Recommendation Report for Planning Permission

REF NO: EP/69/21/PL

LOCATION: 4 Beechlands Close and
east of 18 Beechlands Court
Montpelier Road
East Preston
BN16 1JZ

PROPOSAL: 1 No. 3-bed bungalow (resubmission following EP/10/21/PL). This site is in CIL Zone 4 & is CIL Liable as new dwelling.

Client	Description
c/o RSP ARCHITECTS LTD	PROPOSED PLANS, ELEVATIONS & SECTION

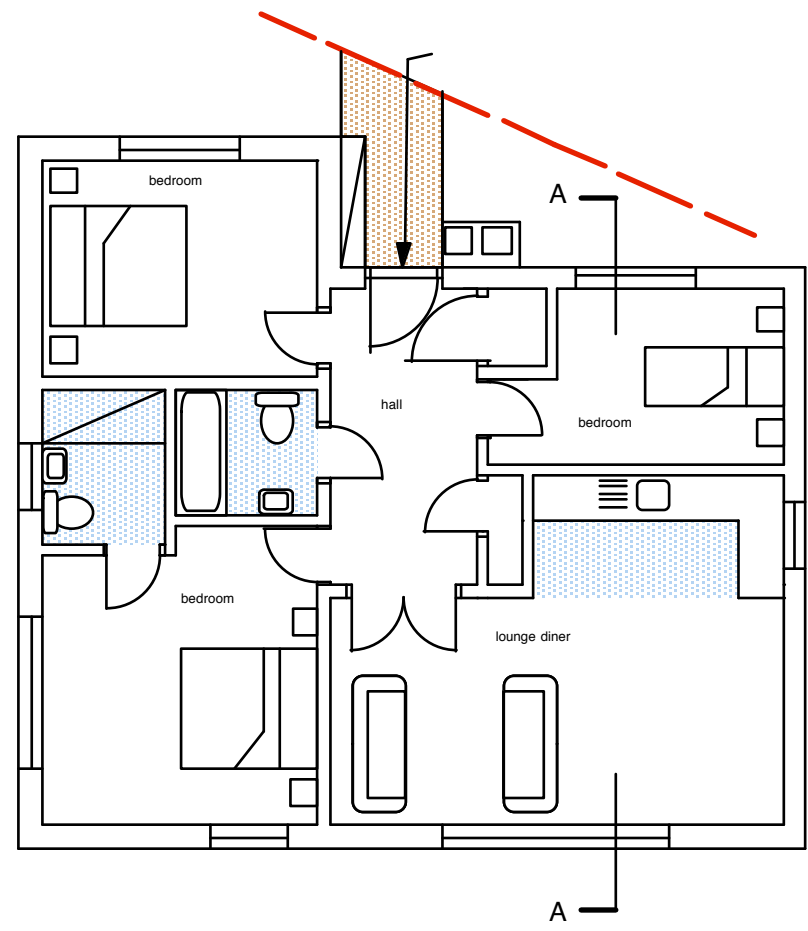
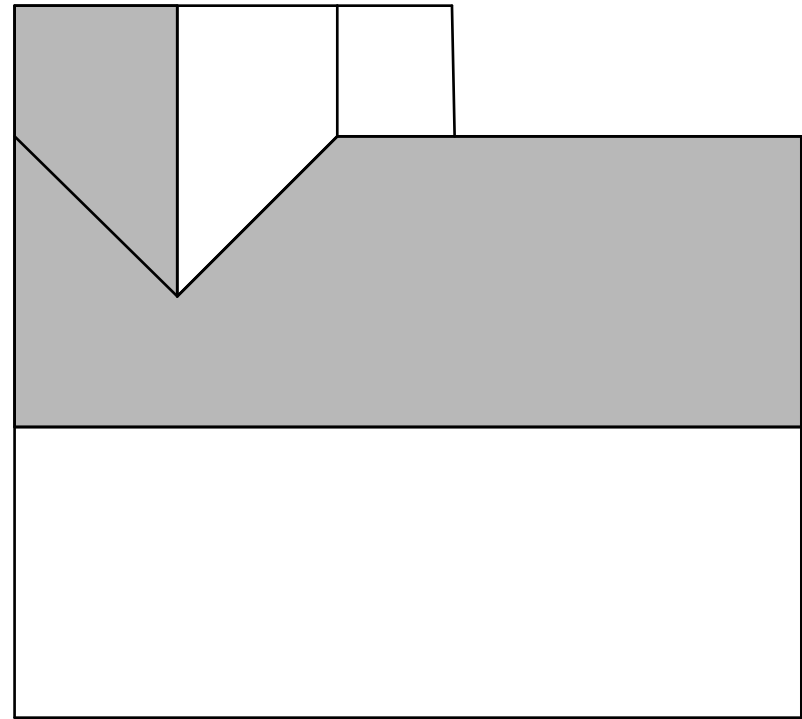
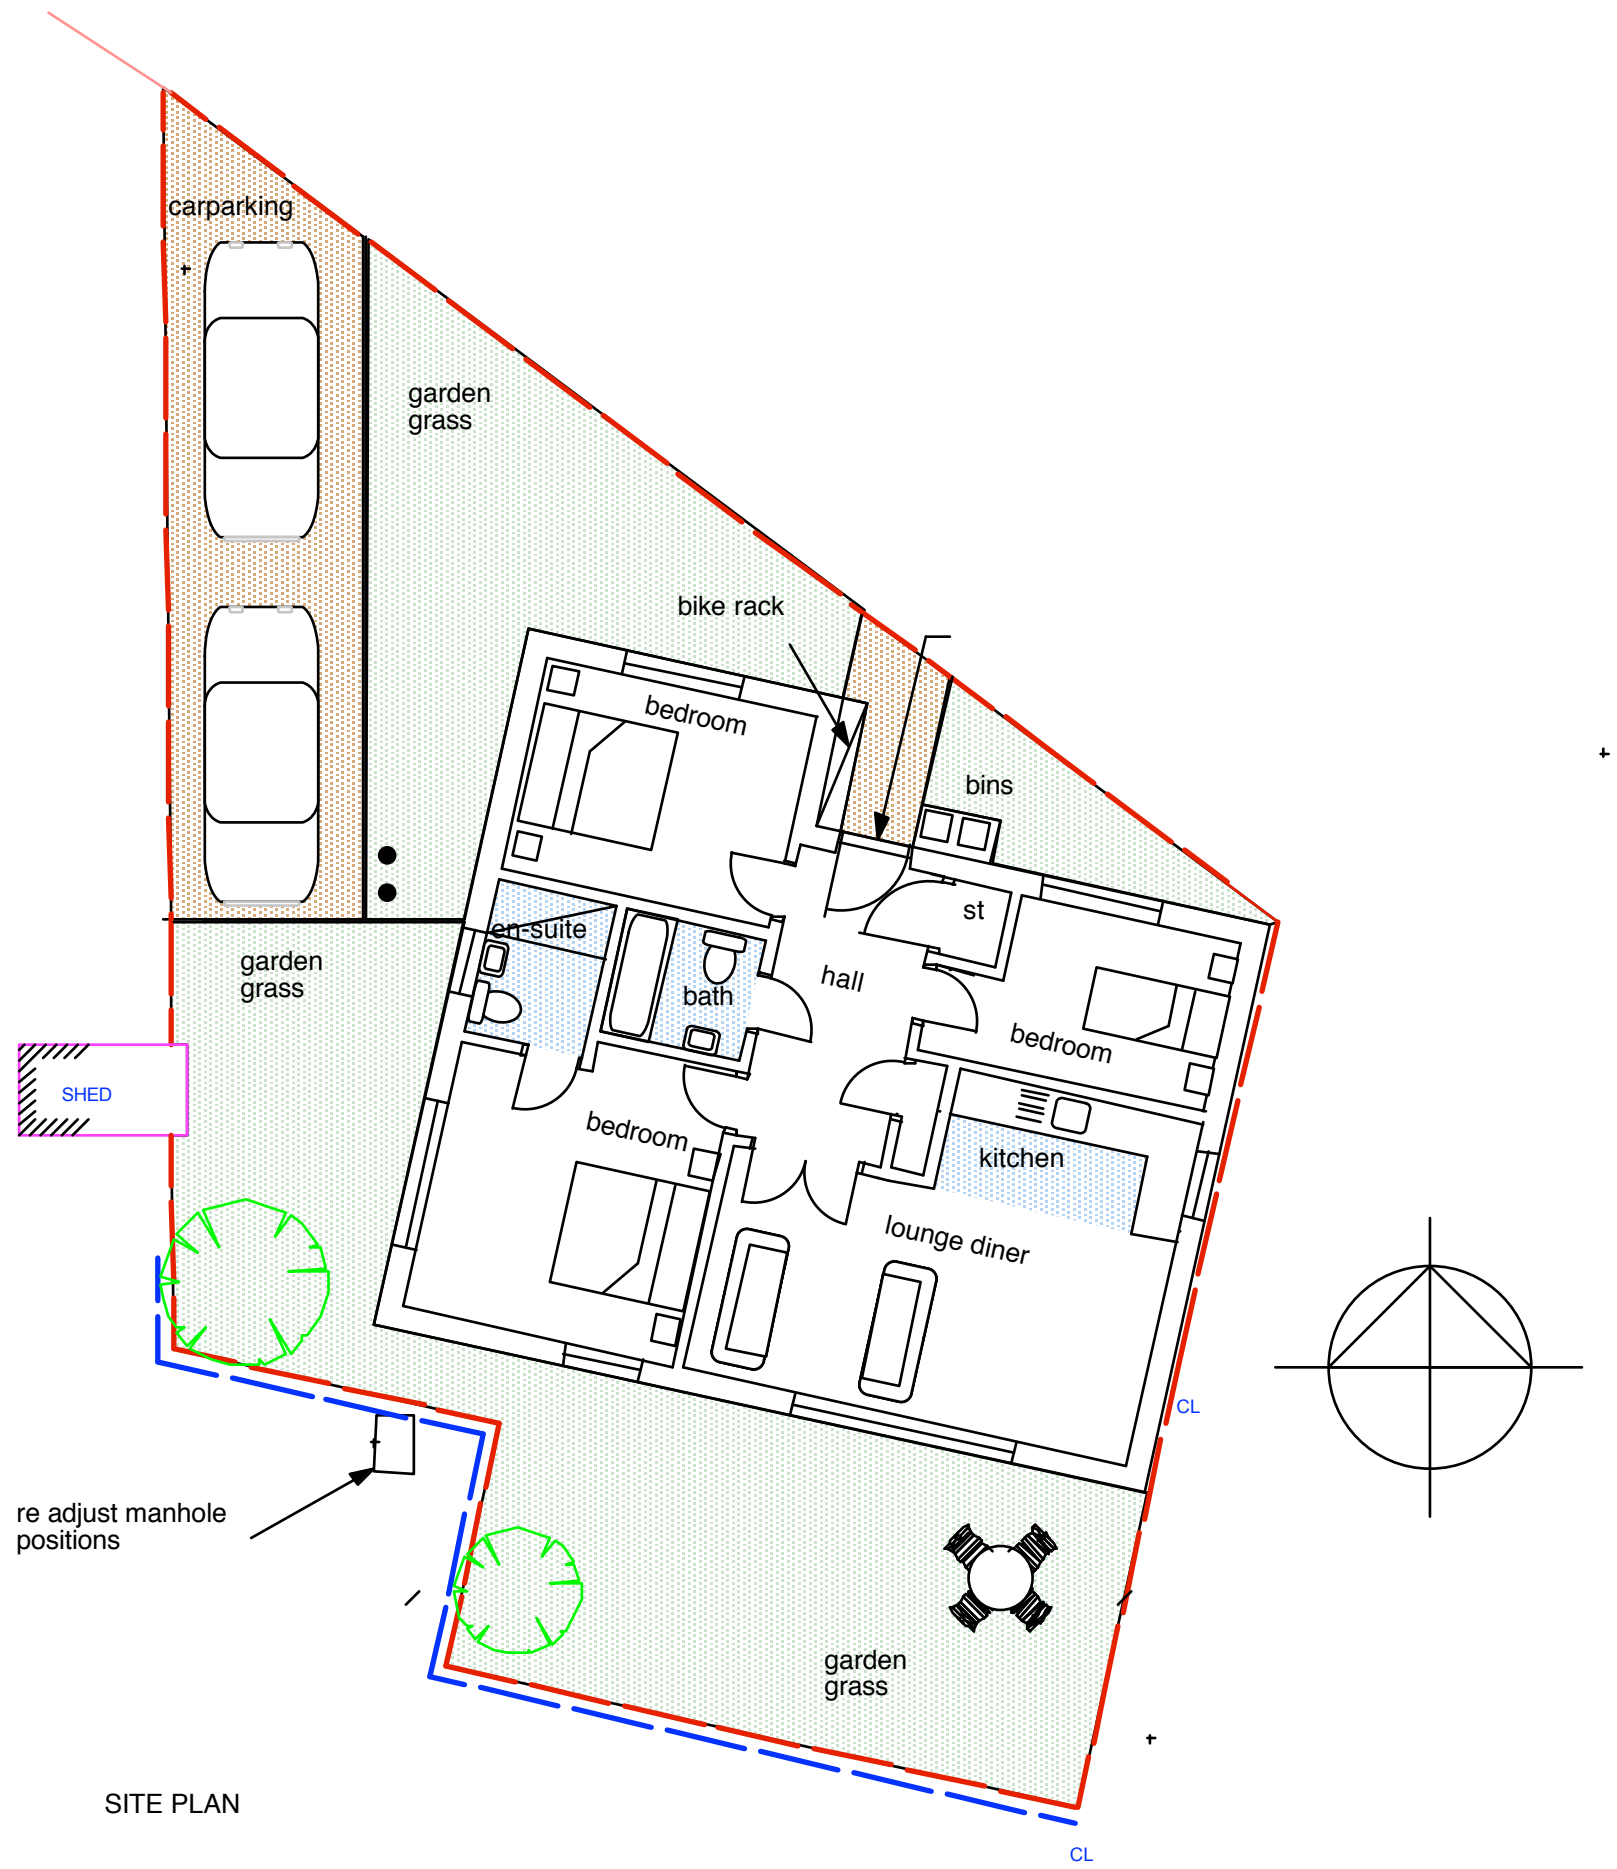
The provision of a bungalow on this limited sized plot would lead to a cramped/overcrowded design. The footprint of the dwelling and lack of space to site boundaries would be out of character with the more spacious layout of the adjacent bungalows and dwellings which are set back from the road frontage and well integrated into the street scene.

The layout and position of the dwelling appears cramped, contrived and would fail to appear integrated

with existing larger neighbouring properties and plot widths. The dwelling would be too close to the road frontage in Montpelier Road providing a poor relationship and would not contribute positively to the street scene. It would be prominent and obtrusive and lack sufficient space for any meaningful landscaping to assist in the integration of the dwelling in the street scene.

This proposed infill does not match the spacing, layout, pattern and plot width in the area or provide a cohesive and unified response to its siting and the prevailing character. It has no space to its east side boundary, front (north) boundary and the area to the west of the property would be occupied by car parking. The rear garden is an irregular shape with a tight pinch point and a maximum depth of 4.2m.

The rear ground floor windows of the bungalow would have poor levels of light, given the limited garden depth and proximity to boundary fencing and would suffer from an overbearing impact from the proximity of 4 Beechlands Close. The outlook from the front bedroom would also be poor facing onto the bin storage area.

A 3 bed single storey dwelling, for up to 4 persons requires 74m². The floor area of 72.76sqm is below this and the dwelling is not in accordance with the standards. A single bedroom should have a floor area of 7.5m², one of the bedrooms is below 7sqm, again in conflict with this standard.

However, the proposal makes limited and unacceptable provision for private amenity space given its limited width and dog legged shape. It has 3.5m width to the side. The rear depth is 4.18m below the accepted standard. Arun Design Guide (part H) suggests that outdoor residential amenity space should fulfil a variety of functions and accommodate a range of activities and should be of an appropriate size and shape and integrated with surrounding uses. Is not considered that sufficient useable space is provided. The depth is limited with insufficient space available to provide for outdoor seating, drying clothes and recreation, particularly when the proposal is for a 3 bedroom unit of accommodation which it is anticipated would be occupied by more than one person.

The garage serving the host dwelling would be demolished, but there is ample space available for parking in the front garden area of the dwelling. The proposed dwelling requires a maximum of two off street car parking spaces and is compliant in terms of parking provision and acceptable in terms of access. The space available is 9.5m long by 2.8m wide which could accommodate 2 cars in tandem. The 20% provision for visitor parking could be accommodated on street. Provision of electric vehicle charging points (indicated on the site plan) and cycle parking can be conditioned in line with requirements. A bicycle rack is indicated on the site plan, but cycle parking should be covered.
